**Addendum to Apex Report 2405.2B
Noise Impact Assessment
Stagecoach Bus Depot Extension
Barnsley**

Report Number: 2405.2
Version: B Addendum Second Issue
Date: 26th August 2011

- 2.1 This addendum to Apex Report 2405.2B dated 20th June 2011 has been produced in response to the queries raised by Lucy Allen, Senior Environmental Health Officer at Barnsley in her email dated the 12th August 2011.
- 2.2 This document should not be read as a standalone report and should only be read in conjunction with Apex Report 2405.2B.

SITE PLAN AS PROPOSED

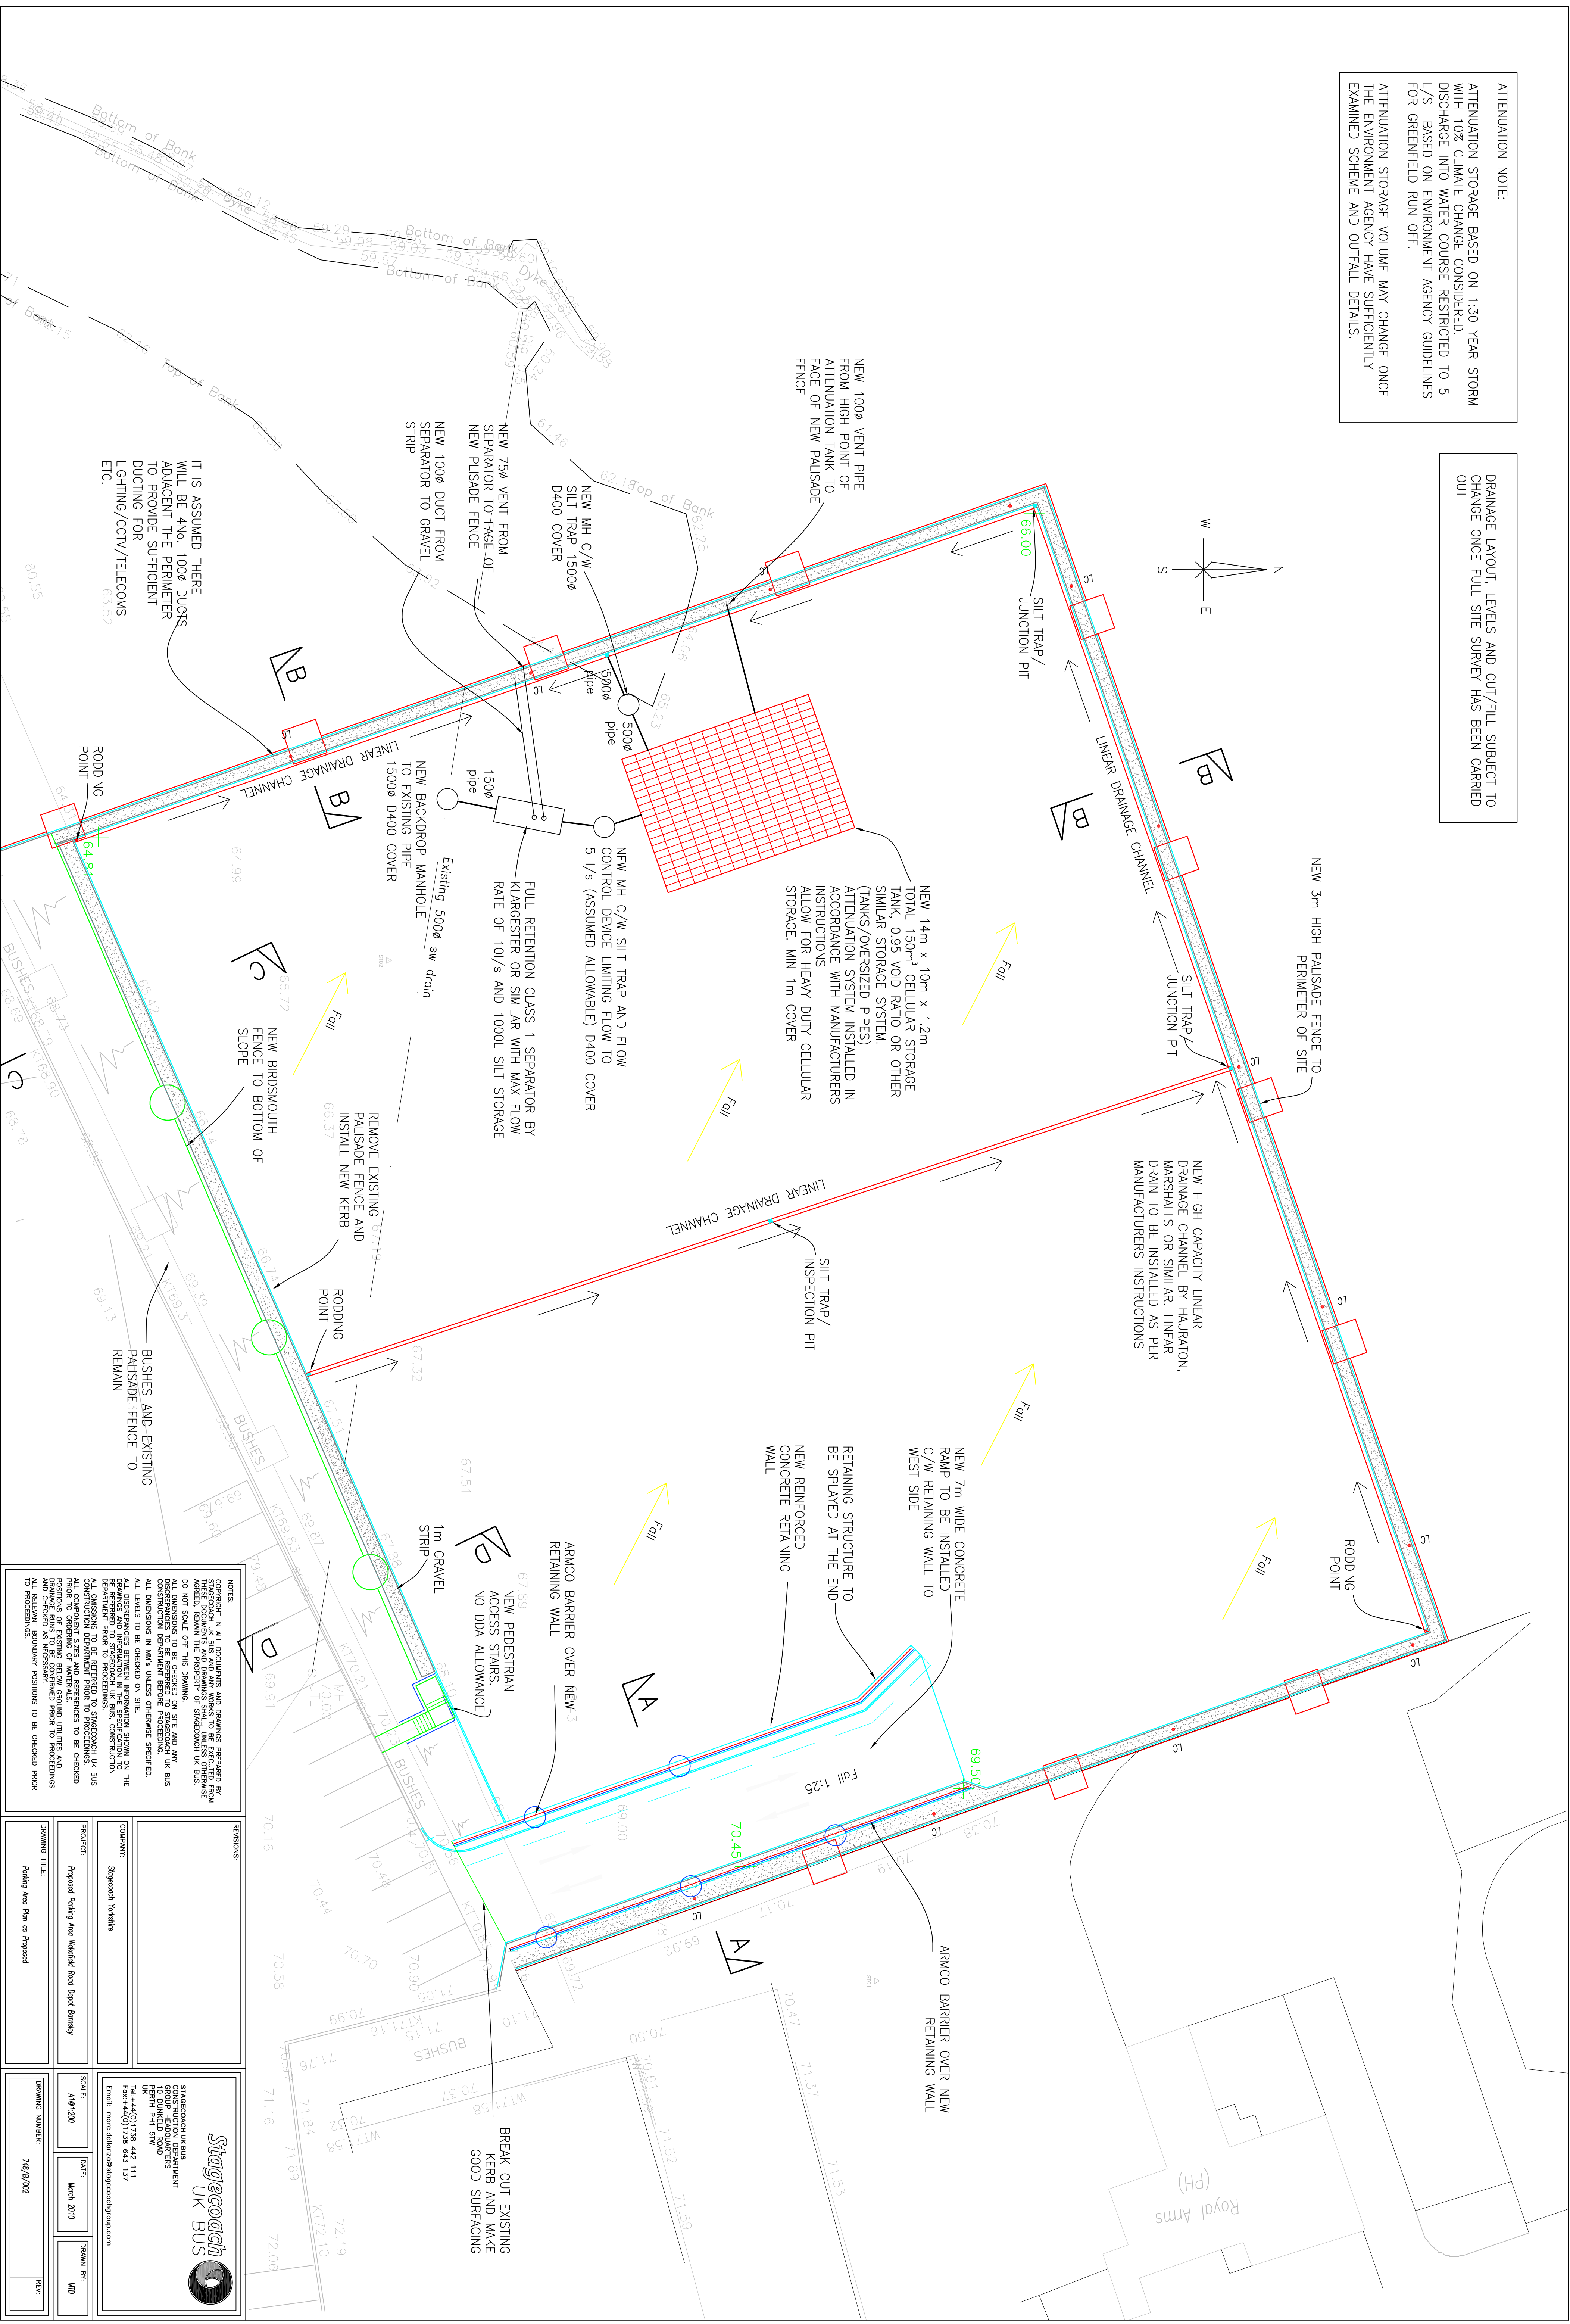
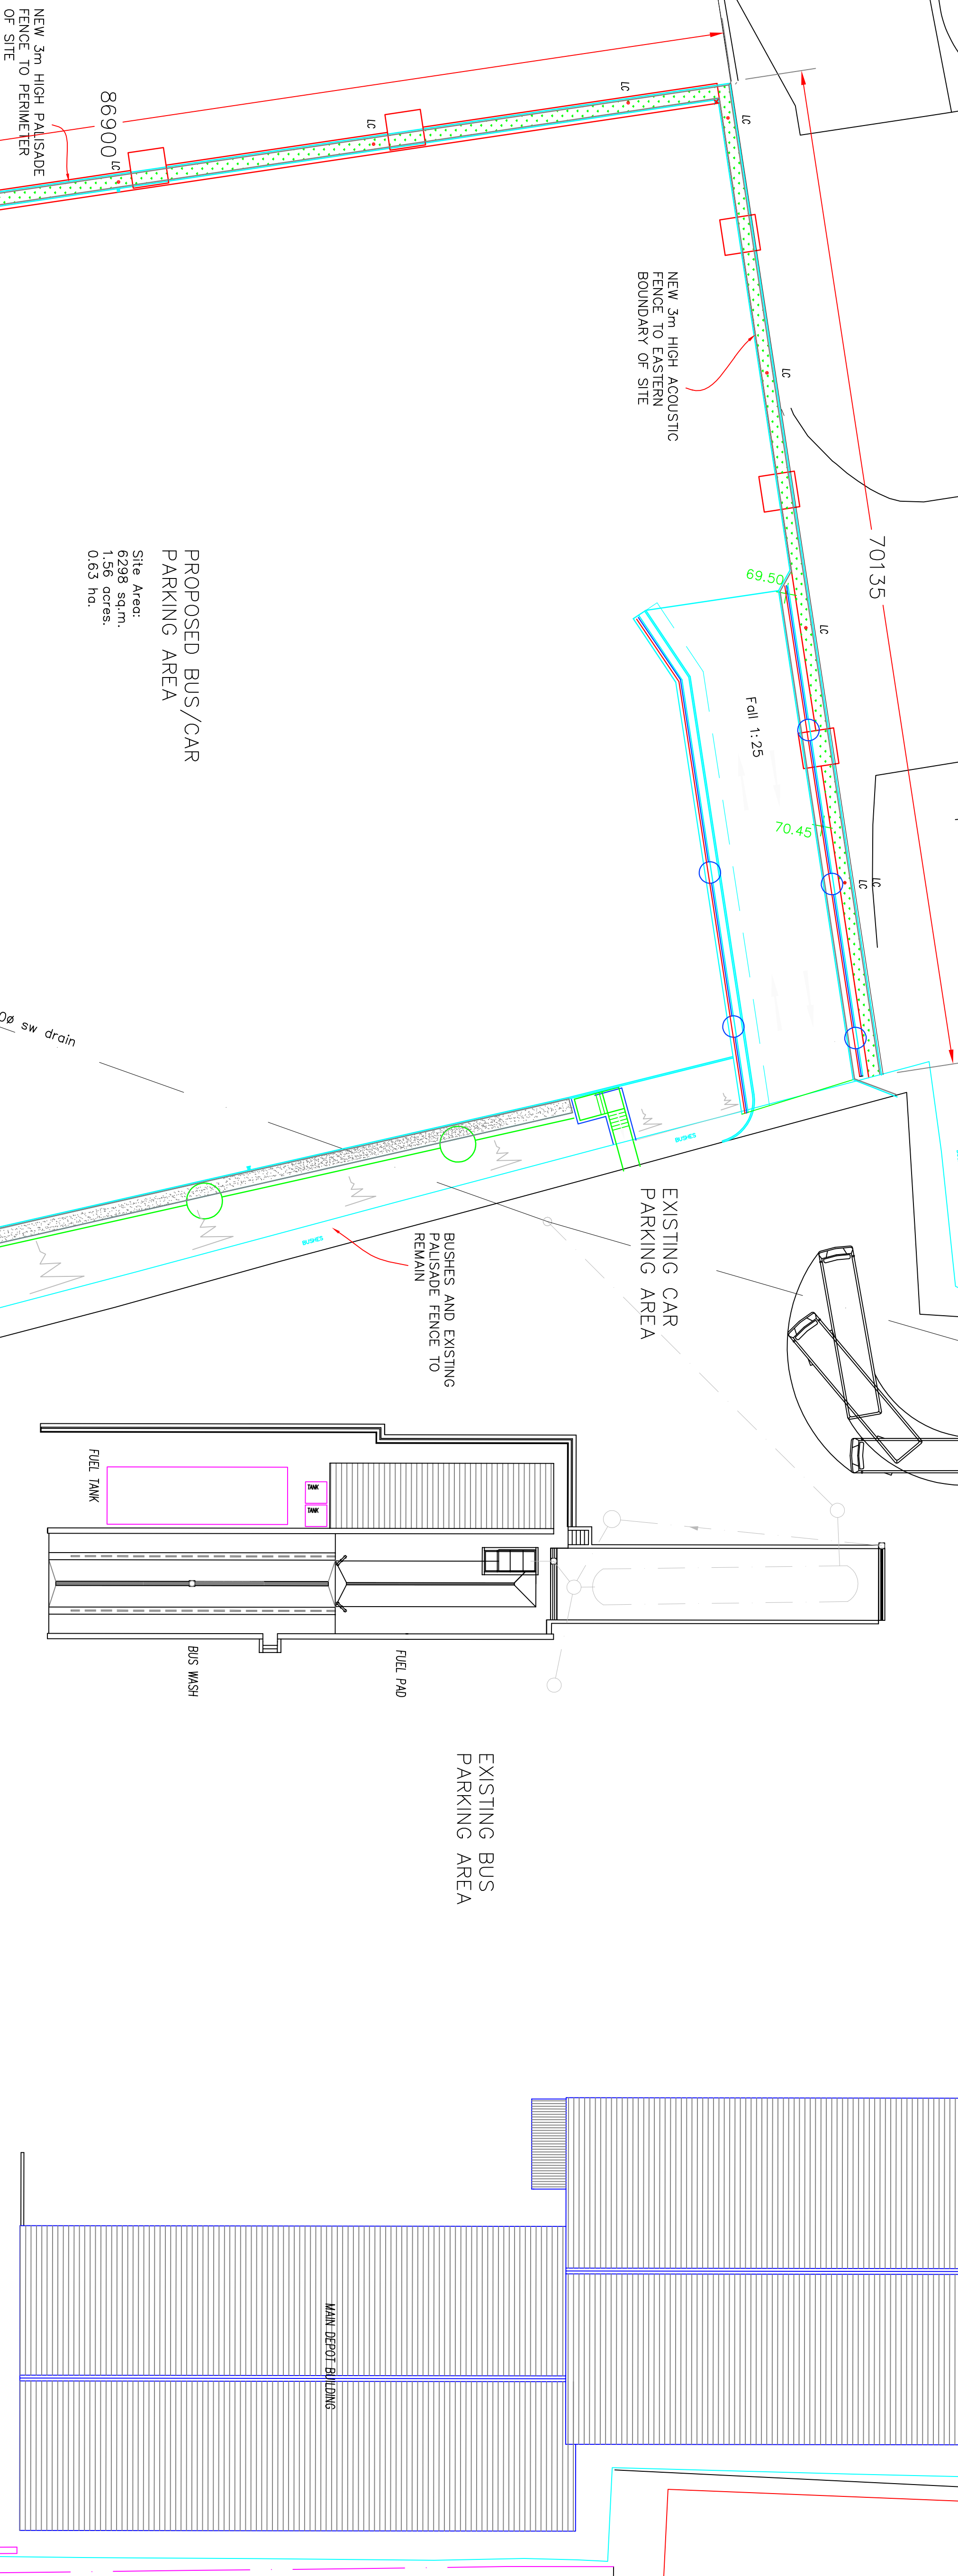
- 3.20 I also note that the ramp leading to the additional parking area runs immediately to the rear of the proposed residential properties and would question whether the applicant has considered access to the new parking area along the western boundary of the site which would distance the noise from the residential properties.

- 3.21 The noise impact had been evaluated on the basis of the proposed scheme.
- 3.22 Furthermore it would be useful to have a printout of the parameters used in the noise modelling software.
